Subject: Concept Plan (MP08_0207) & Project Application (MP10_0219) - Residential development at Avon and Beechworth Roads, Pymble

SCHEDULE 1

B. Stage 1 Project Application

FIGURE 9 – BUILDING SEPARATION BETWEEN BUILDING 3 AND 1 ARILLA ROAD

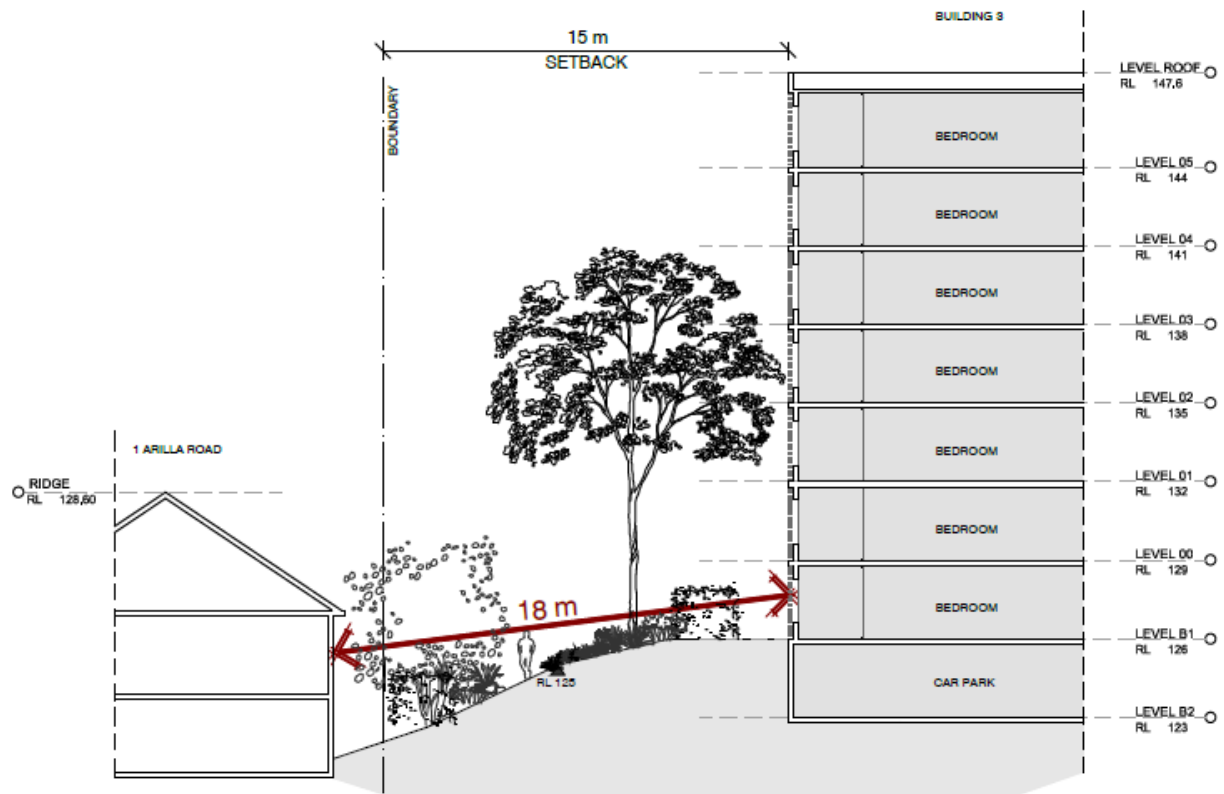
- confirmation of the physical separation between existing dwellings on adjoining properties and the proposed development (including basement footprints). The Department notes a number of anomalies between the information presented on the Survey drawings and the Architectural and Landscape Plans – eg. No. 1 Arilla Road and No. 14 Avon Road;

- further analysis about how the adjoining dwellings at Nos. 3, 7, 11 and 15 Avon Road, No. 1 Arilla Road, Nos. 6, 10A and 10B Beechworth Road present to the subject site. In this regard, details of the elevations in these adjoining dwellings, together with information about the nature of the internal spaces and the adjacent private outdoor spaces which interface with the subject site should be provided together with an assessment of the likely impacts on the privacy and amenity of these properties; and

FIGURE 11 – BUILDING SEPARATION BETWEEN BUILDING 5 AND 6 BEECHWORTH ROAD

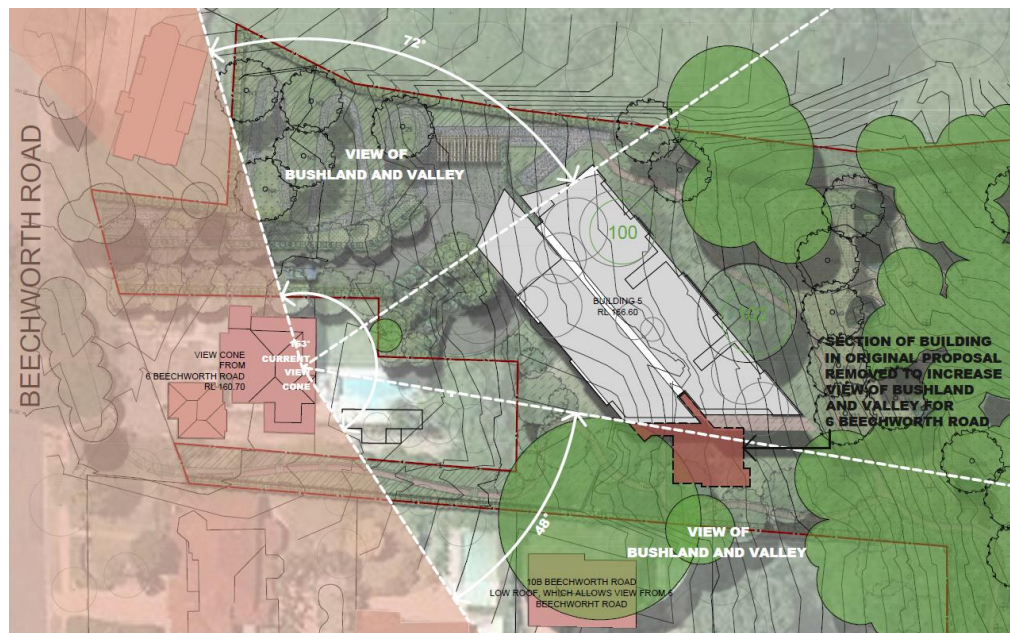
- further assessment of the impact of the proposed development (and specifically Building 5) on the existing heritage item at No. 6 Beechworth Road;
- the Office of Environment and Heritage has requested further analysis of the potential indirect impacts of the development on native vegetation within the proposed conservation area;

FIGURE 14 – PROPOSED DEEP SOIL ZONES

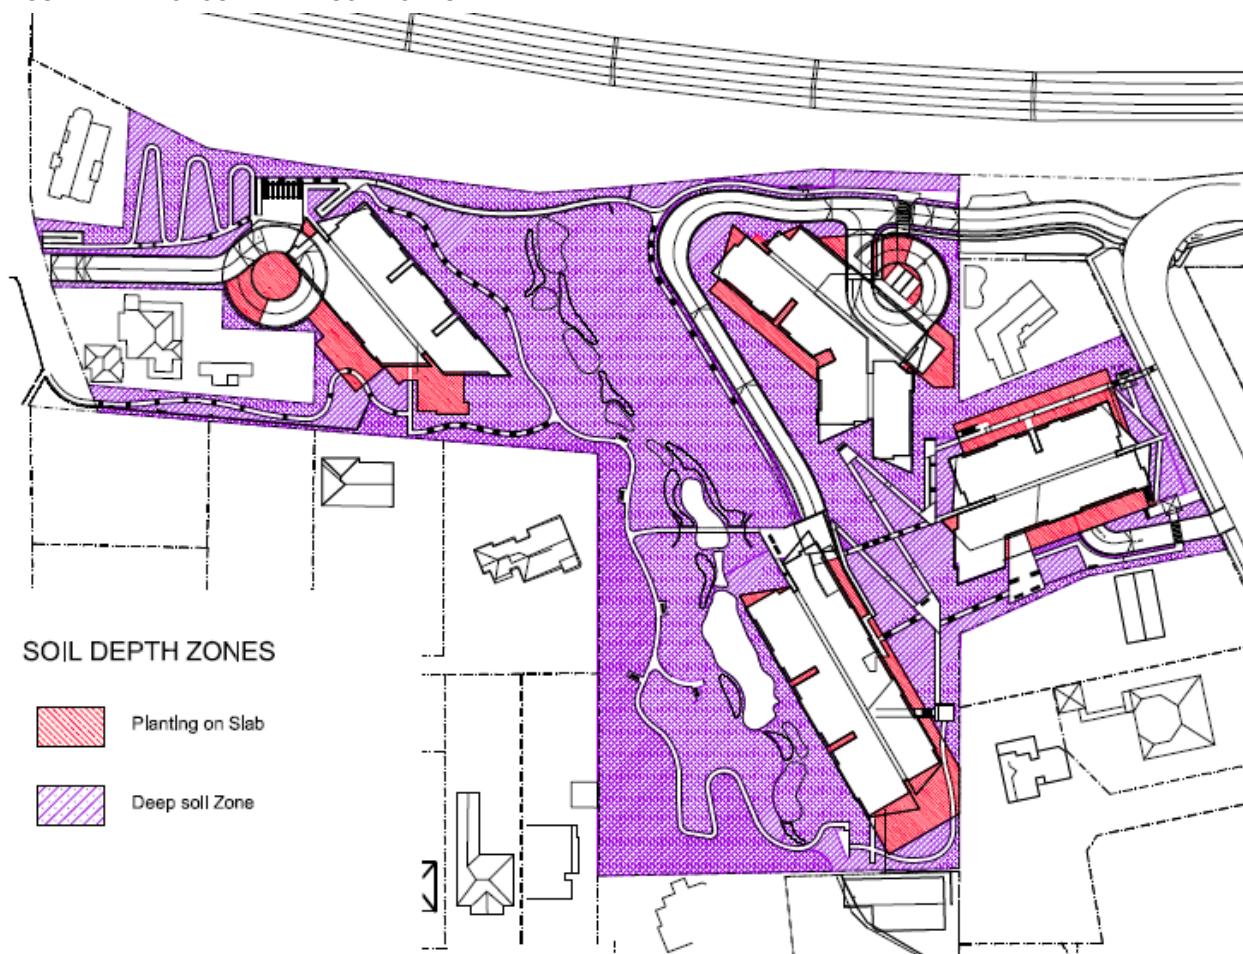
The basement of the Stage 1 building significantly encroaches into the Avon Road setback / deep soil zone. The Department concurs with Ku-ring-gai Council's concerns in this regard and it is requested that the basement be reconfigured to provide a more generous dimension between the basement and the Avon Road boundary to increase the area of deep soil and contribute to the garden setting which is characteristic of this locality.

- correct identification of adjoining properties – for example No. 10B Beechworth appears to have been mis-labelled as No. 10A;
- the deep soil zones identified in the landscape plans are inconsistent with the basement plans included in the architectural drawings, in particular Building 1 in the Avon Road setback.

FIGURE 17 – PHOTOMONTAGE ALONG ARILLA ROAD

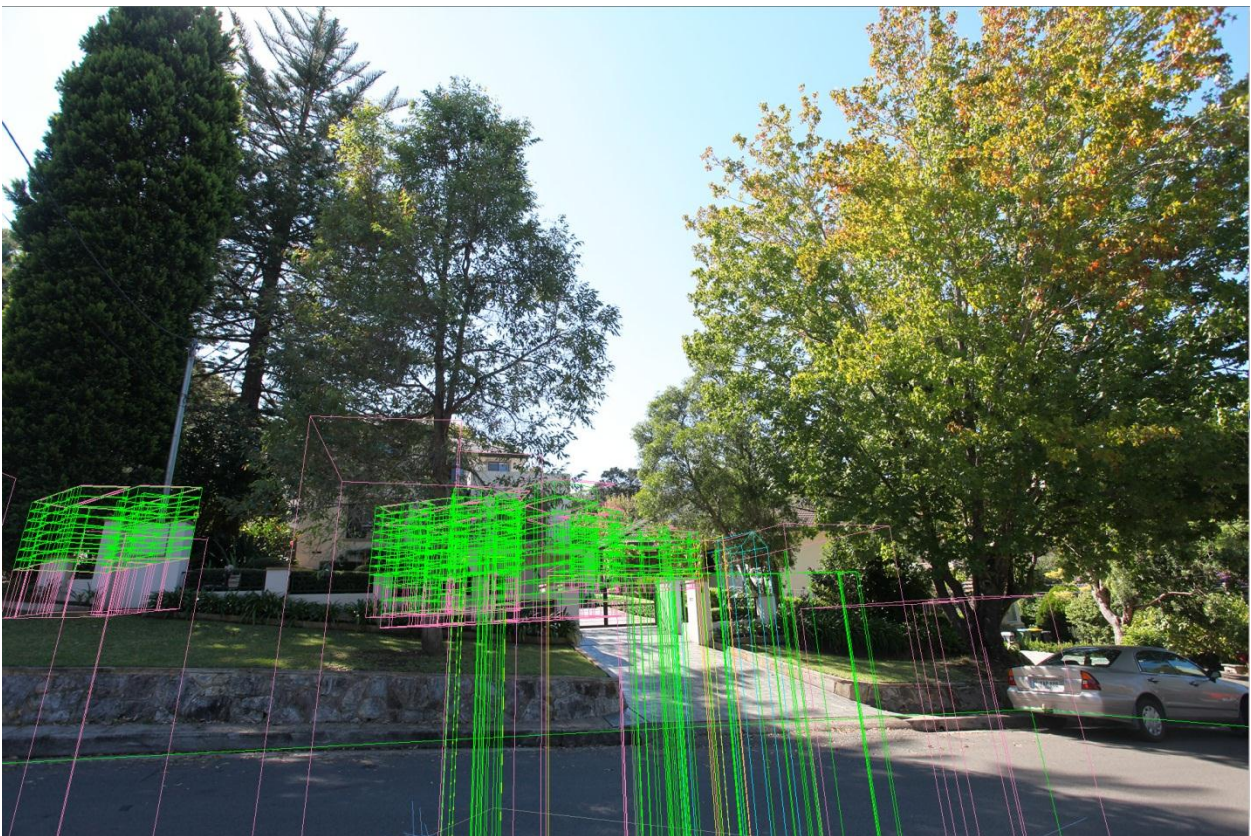
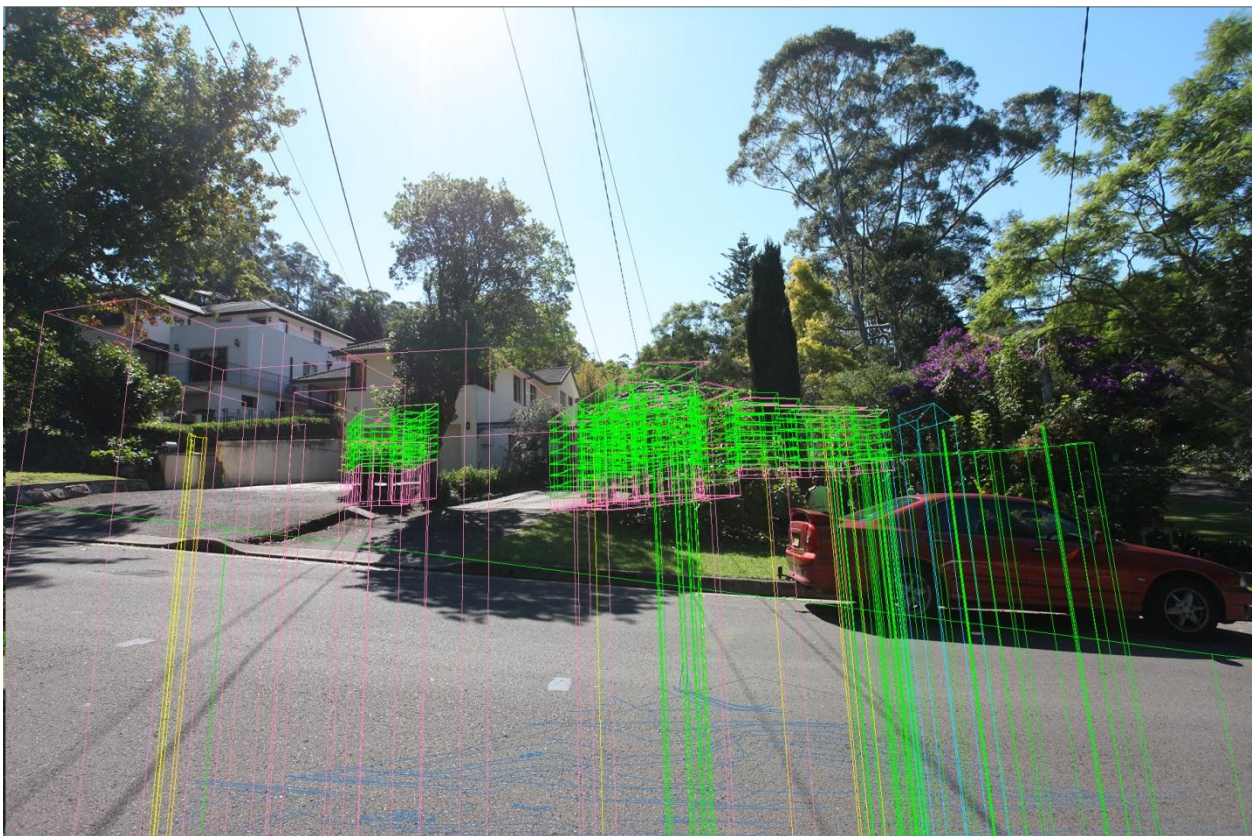
- revised Statements of Commitments where appropriate, providing a response to the Department's key issues and those raised by other agencies;
- perspective studies of the development when viewed from Arilla Road and along the section of Avon Road adjacent to the rail corridor would assist the Department in making an assessment of the impact of the proposed development on the public domain.

Figure 2 Pedestrian Refuge at Site Access

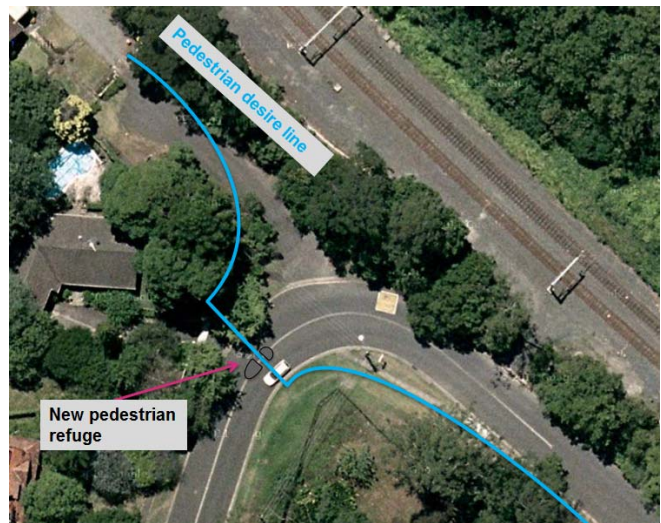
- Council has indicated that a pedestrian refuge is an acceptable alternative to the marked pedestrian crossing at the curve of Avon Road as described in the PPR. Further advice as to the feasibility of providing a refuge in this location to facilitate the safe movement of pedestrians across Avon Road should be provided.
- Further clarification / confirmation regarding the staging of the various infrastructure works is required. The PPR and supporting documentation has not clearly identified the extent of infrastructure works that are to be provided at each stage of the development. This should be specified in the Statement of Commitments.

**Figure 4 Building 1 Servicing Arrangements**

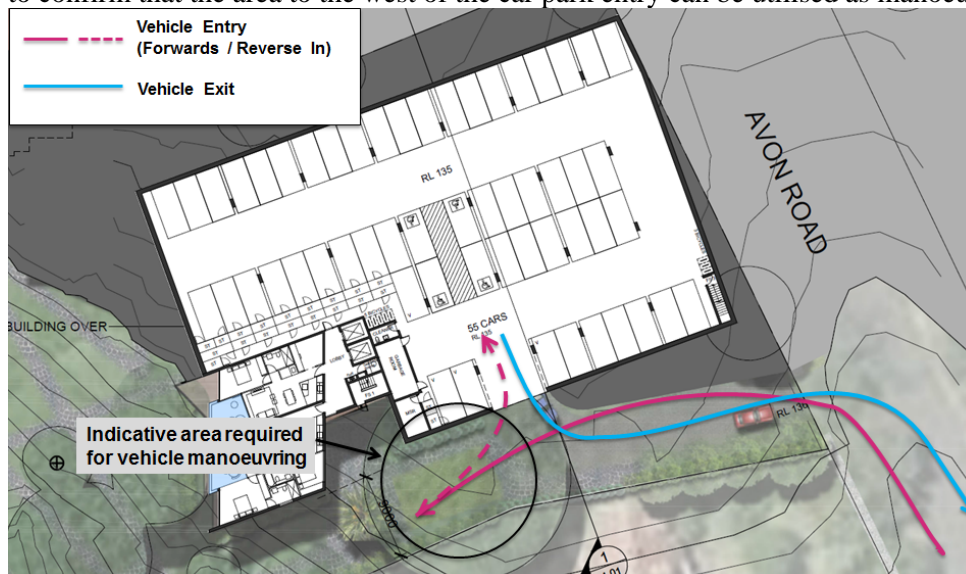
- dimensions to illustrate basement clearance – to ensure that waste vehicles can access the garbage store;
- amended basement plan should also be fully dimensioned;
- confirmation of the number of accessible dwellings in Building 1 – Access Report suggests 5 whereas the architectural drawings show 4;
- further detail to be provided in relation to planting palette for Building 1 – species, size etc to demonstrate achievement of BASIX commitments;
- WSUD report indicates rainwater tank and on-site detention tank are to be provided in the basement however this is not reflected in the architectural drawings. This should be detailed in the amended basement design.
